24 April 2020

SECTION 4.55(2) MODIFICATION 3 TO SSD 7037 | 75-85 HARRINGTON STREET, THE ROCKS | RESPONSE TO SUBMISSIONS

1 SECTION MPB1 TYPICAL
1:10

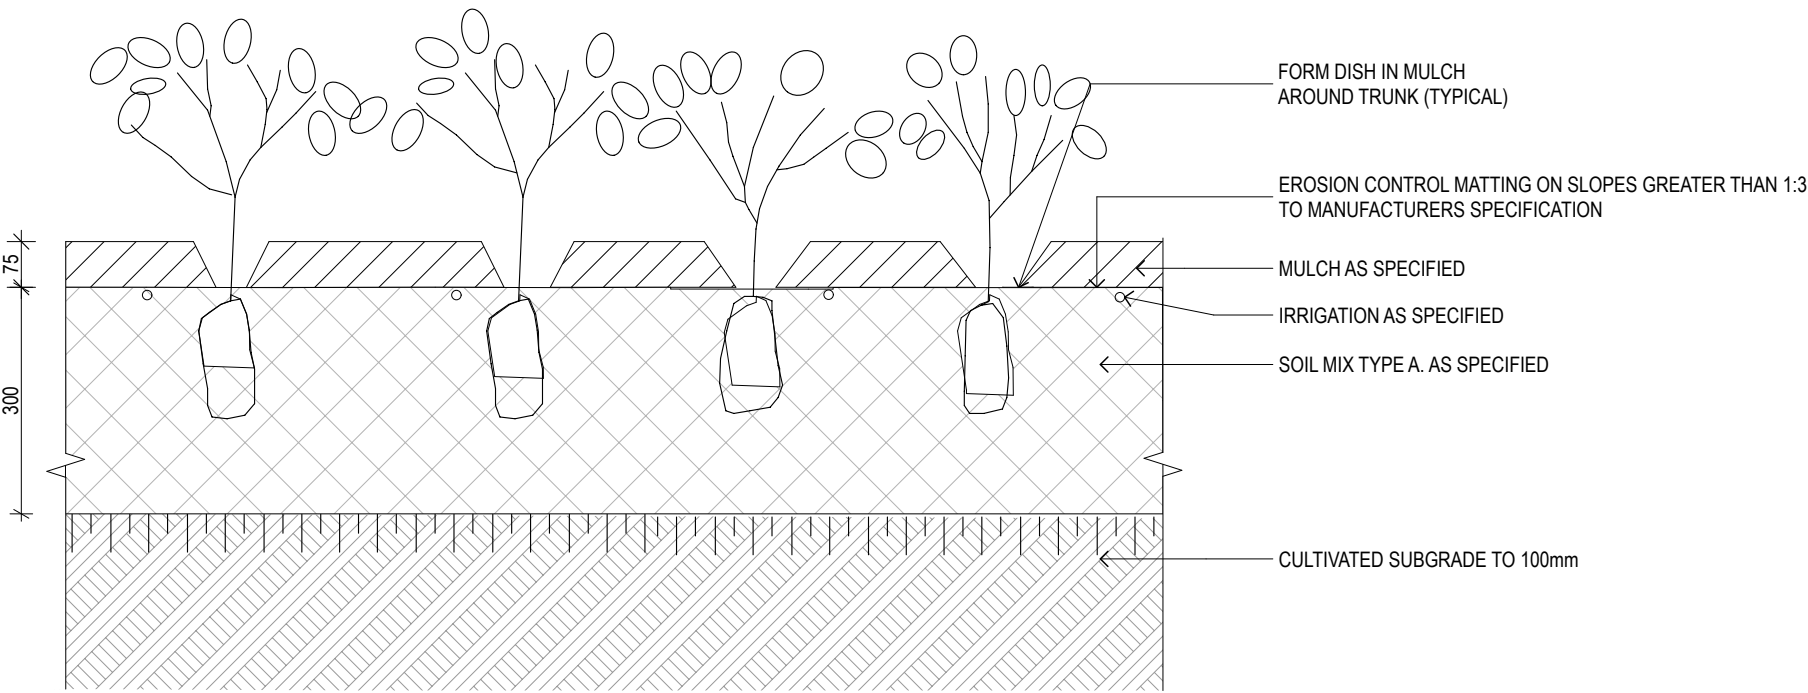
4. There does not appear to be any detail shown on the landscape drawing as to soil depth profiles and irrigation. If there is to be irrigation (which is a necessity), will it use any rainwater harvested from the development site?	The proposed garden on grade is labelled in the submitted architectural drawing set as 'MPB1 – Mass Planter Bed on Grade' (refer to Drawing 8809 Rev J). A softscape detail sketch (which forms part of the upcoming Construction Certificate package) is attached to this RtS for information, which illustrates appropriate soil depths – refer to Appendix B. In terms of irrigation, the development has a rainwater tank located beneath the public through-site stair which feeds the site-wide planting. A variety of potable water sources will feed the tank, including the rainwater collected from roof catchments, as outlined in the approved BASIX certificate. The Applicant can also explore the inclusion of a tap for manual irrigation and maintenance in the area beneath the ramp (at Construction Certificate stage), if deemed necessary.	Appendix B

project code GA85H sheet no. DA-2011 revision A8

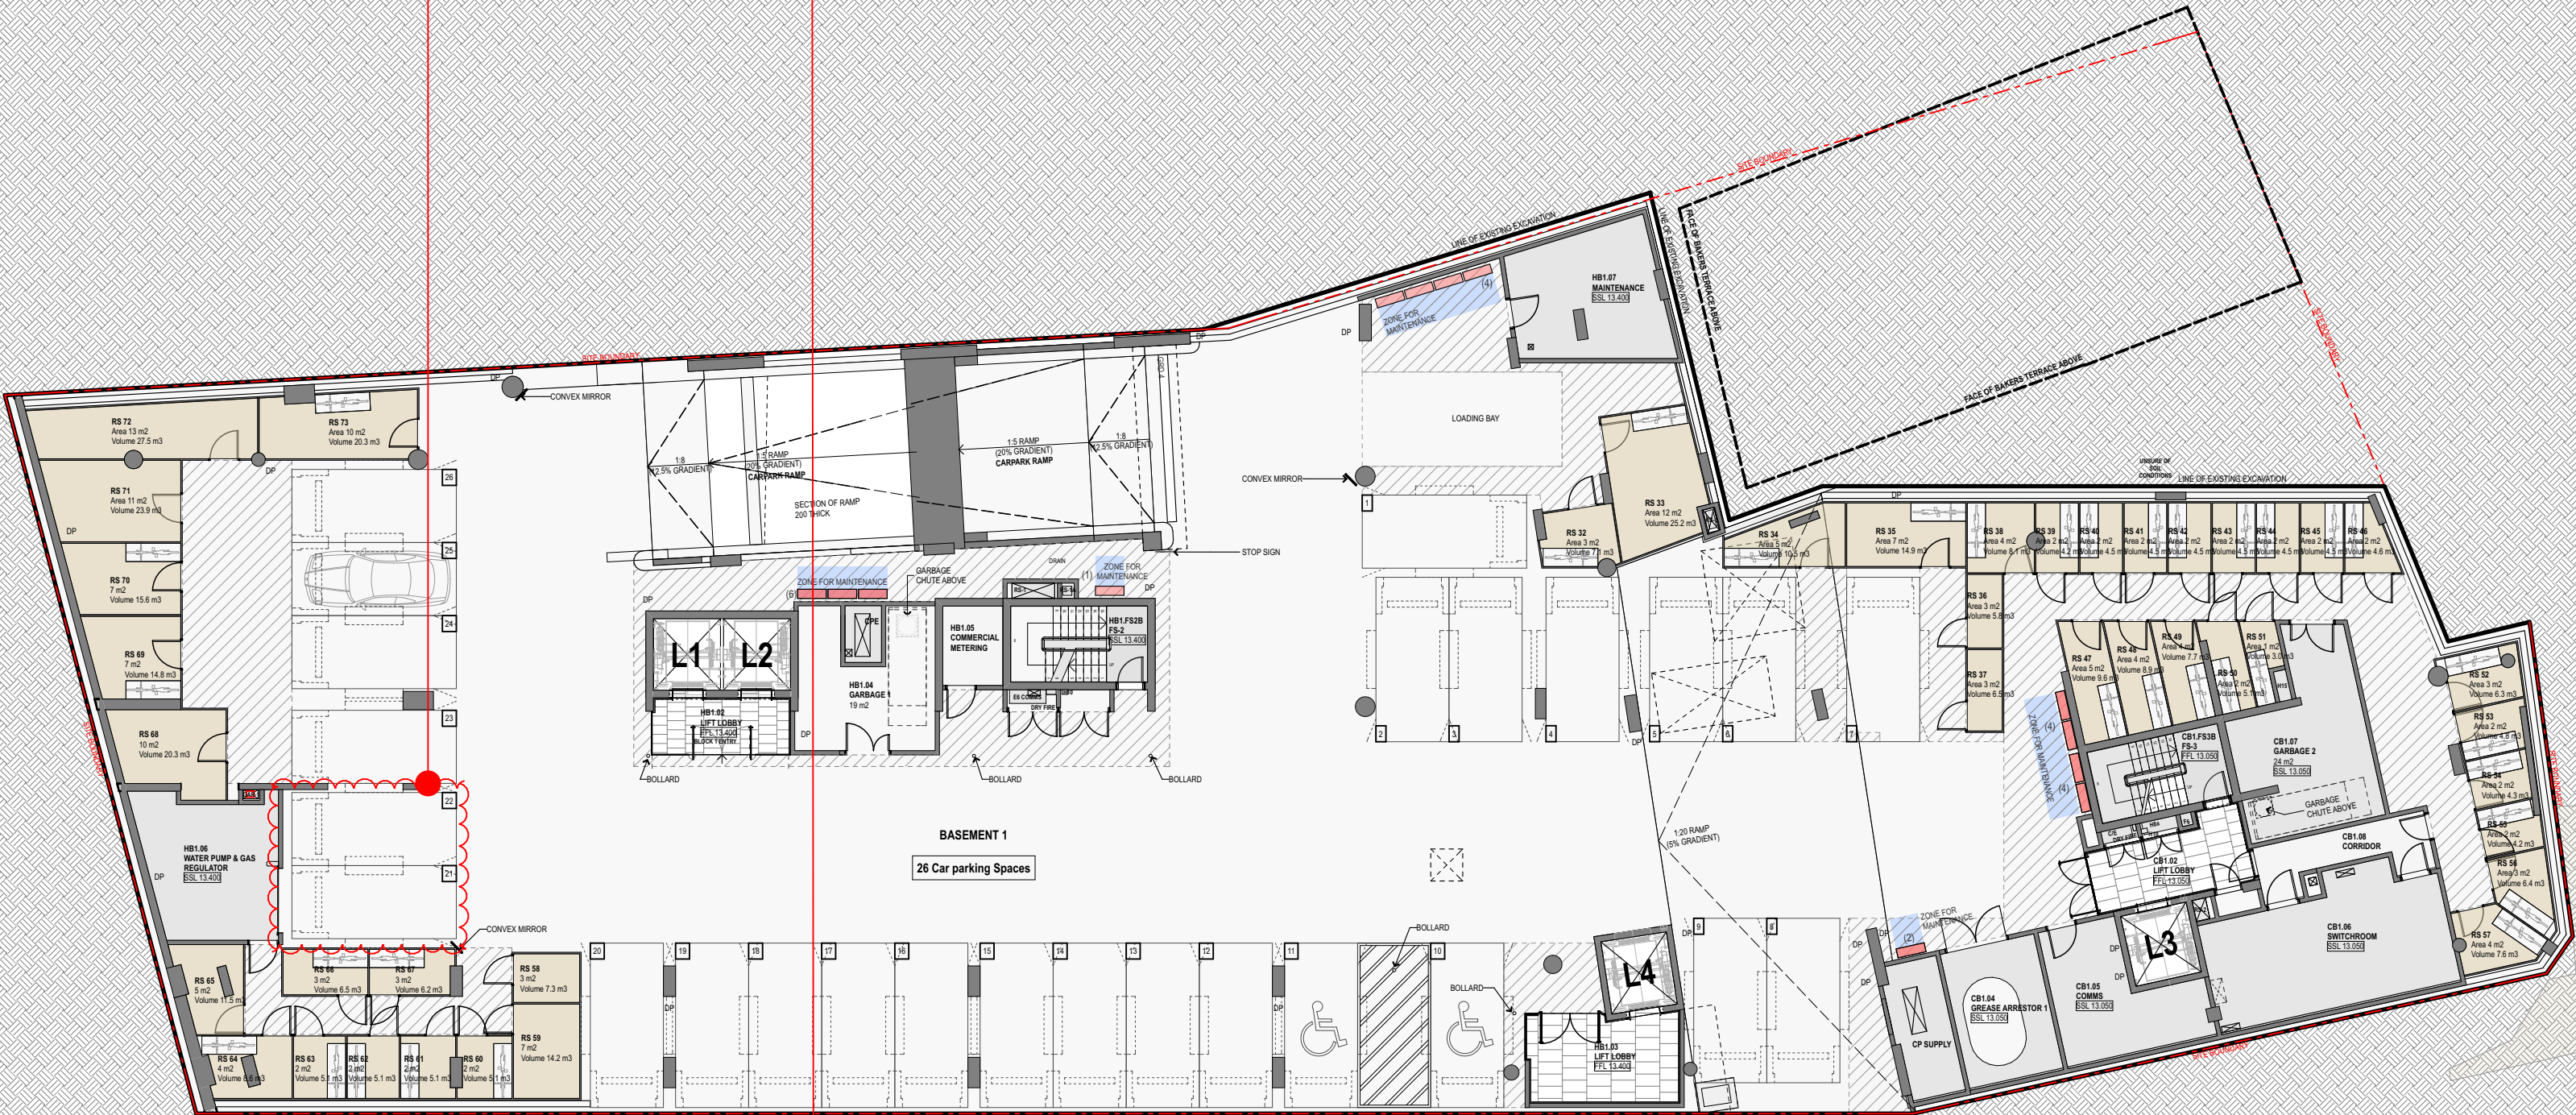
Description of Amendment	Rationale	Impact
1. Redistribution of residential storage cages	Rearrangement for better access and efficiency across both basement levels.	Nil impact. Zero change to the overall quantum of storage area. 58 bicycle parking spaces are retained in accordance with the consent, as modified.

2. Redistribution of parking spaces	For better access, safety and visibility, also improving distancing to/from service and maintenance systems.	Nil impact. Rearrangement results in no change to the number of car parking spaces, or the number of accessible spaces.

scale	As Noted @ A2	first issued	29/03/2018
project code	GA85H	sheet no.	DA-2012
		revision	A8

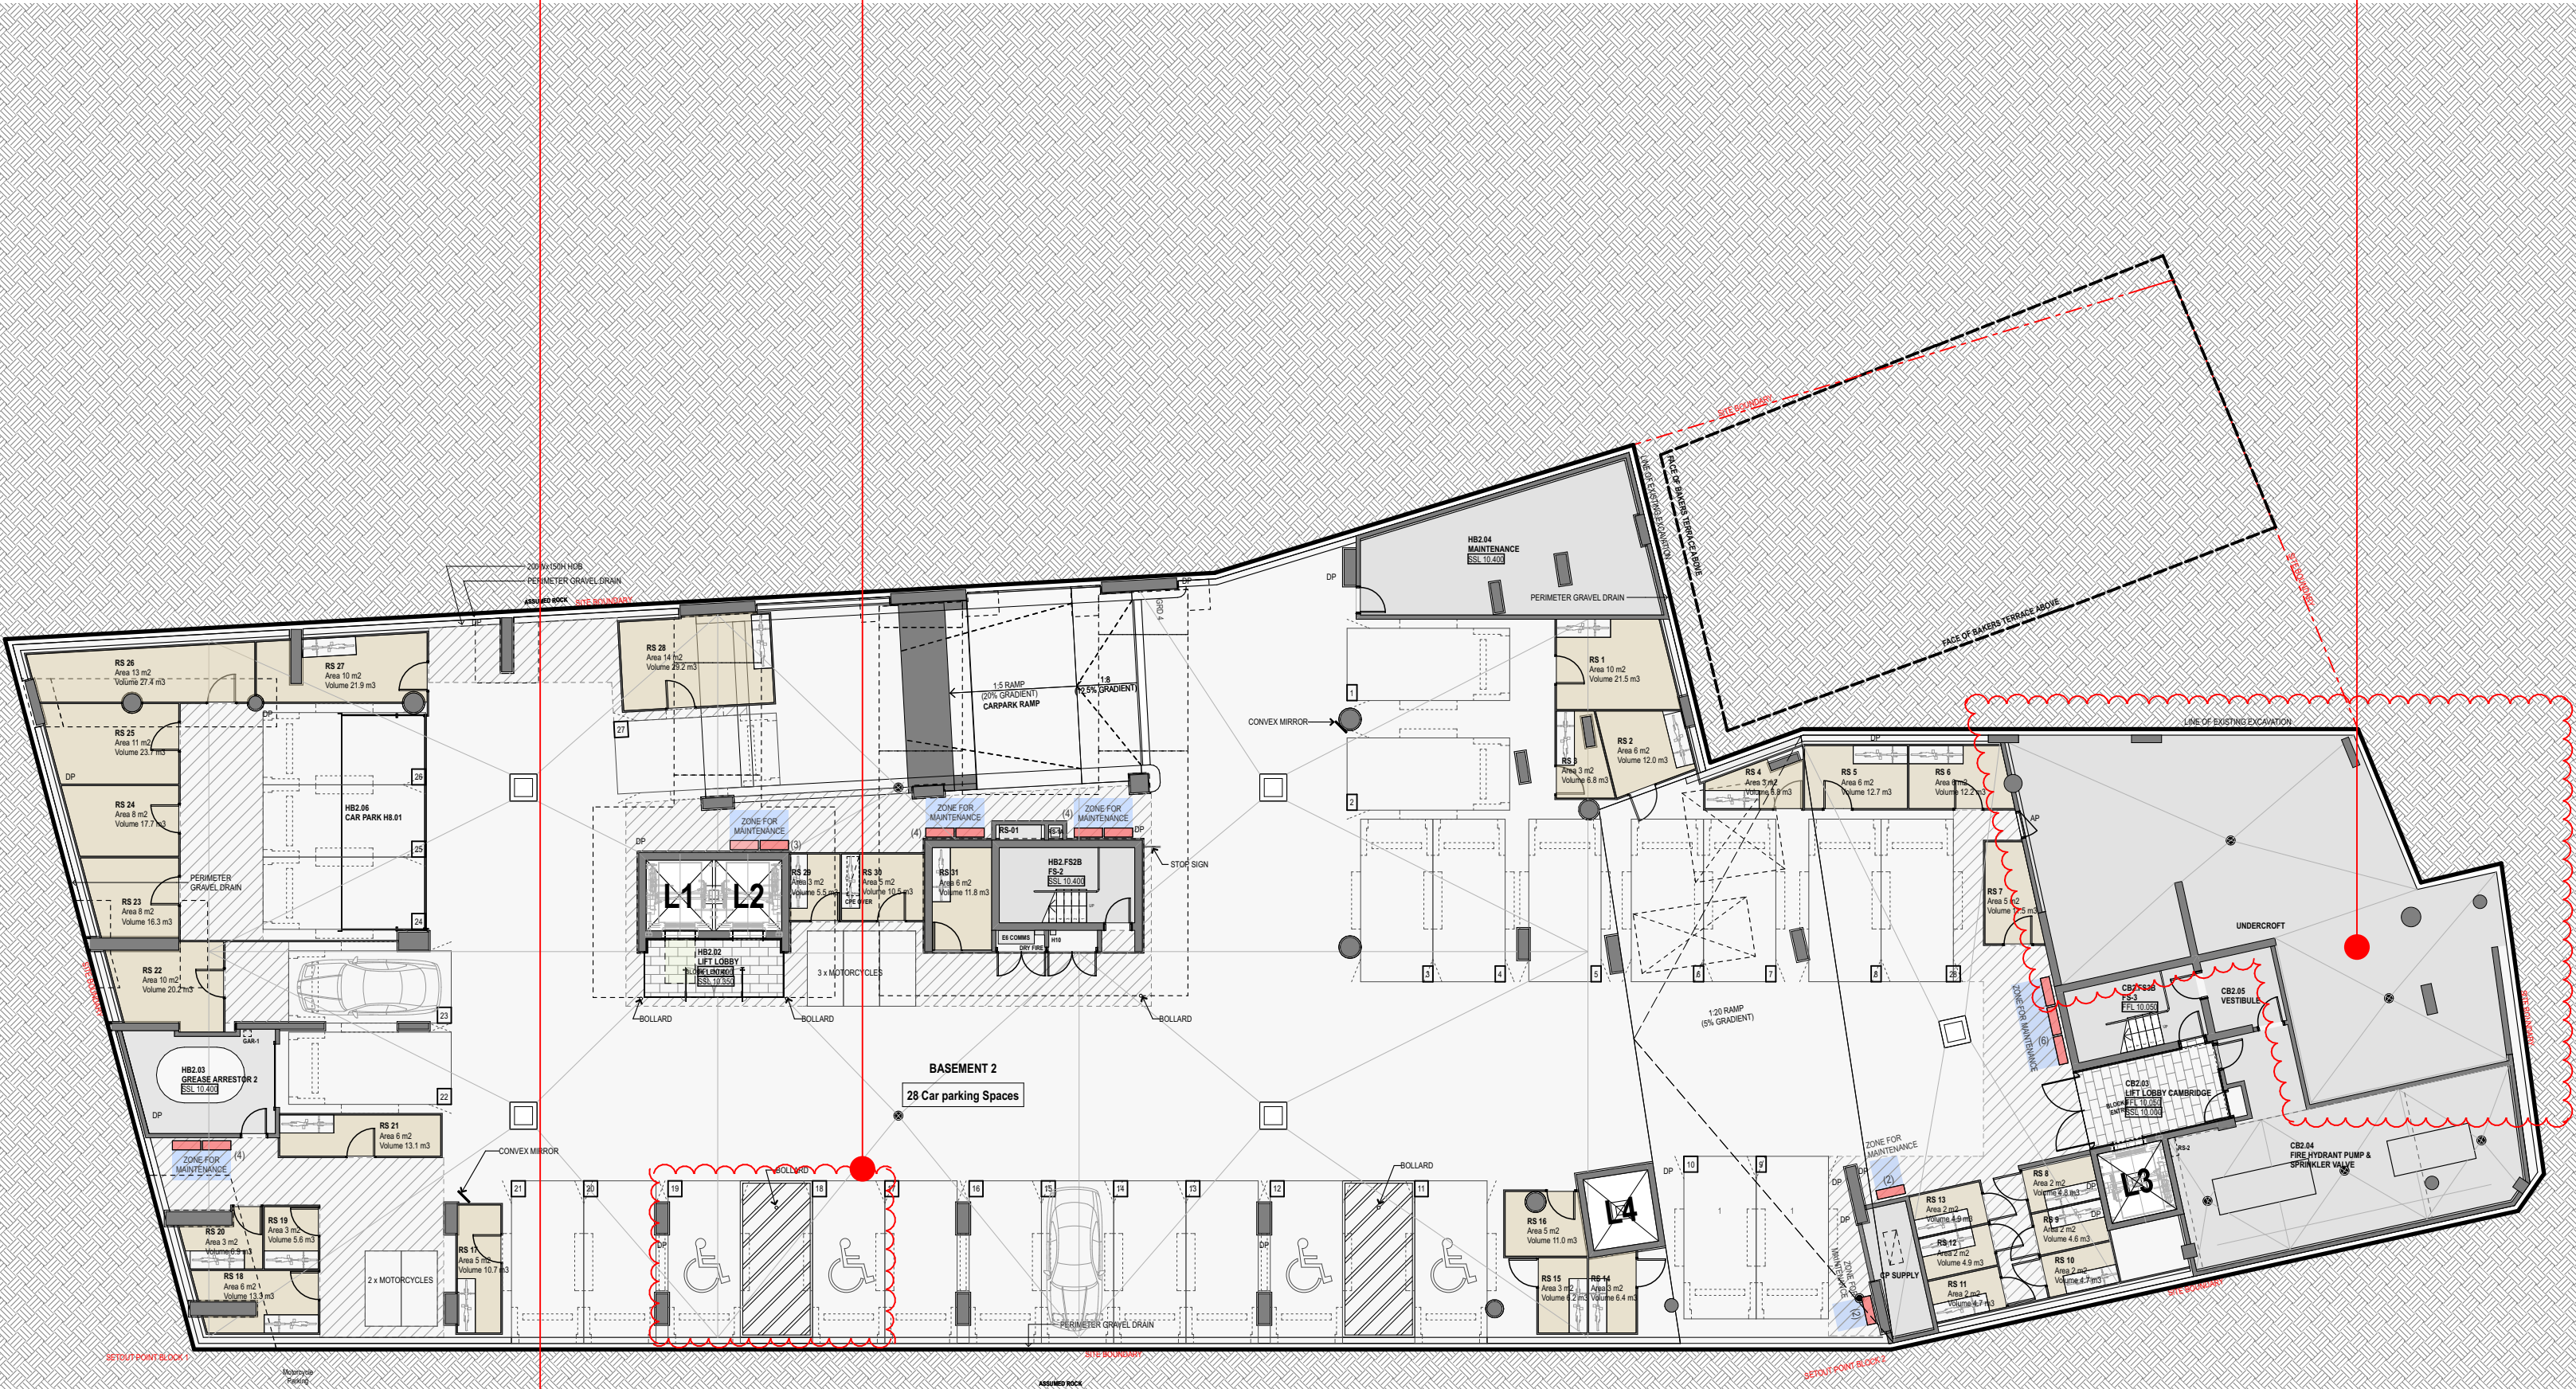
3. Relocation of fire-fighting water tank	Relocated below Cambridge Place courtyard and above Retail on Harrington Street to achieve a gravity-fed Deemed to Satisfy solution with the Fire Engineer and Fire Brigade (FRNSW). <i>See further explanation below.</i>	Nil impact. The basement area (where the tank was formerly located) will be undercroft/not usable and concealed by a block wall. An access panel will be available for maintenance and security control.

By way of further explanation, the Basement 2 water tank is/was proposed for firefighting purposes. After liaison with the Fire Brigade it was deemed too deep to pump from and could not achieve compliance with the Brigade’s requirements/standards (i.e. water pressure, depth of tank etc).

The builder (Icon) developed a Deemed to Satisfy solution, in conjunction with the Fire Engineer, by relocating the tank in the empty space below the courtyard and above the rear of the Cambridge retail on Harrington Street.

The new location allows the water tank to be gravity fed, which is a preferable solution. The relevant architectural drawing (FJMT Ref: 2004) has already been updated (for CC) to incorporate the new tank location and fire-fighting booster assembly. FRNSW have been informed of these changes (via the Applicant's fire engineer/PCA) and have provided endorsement.
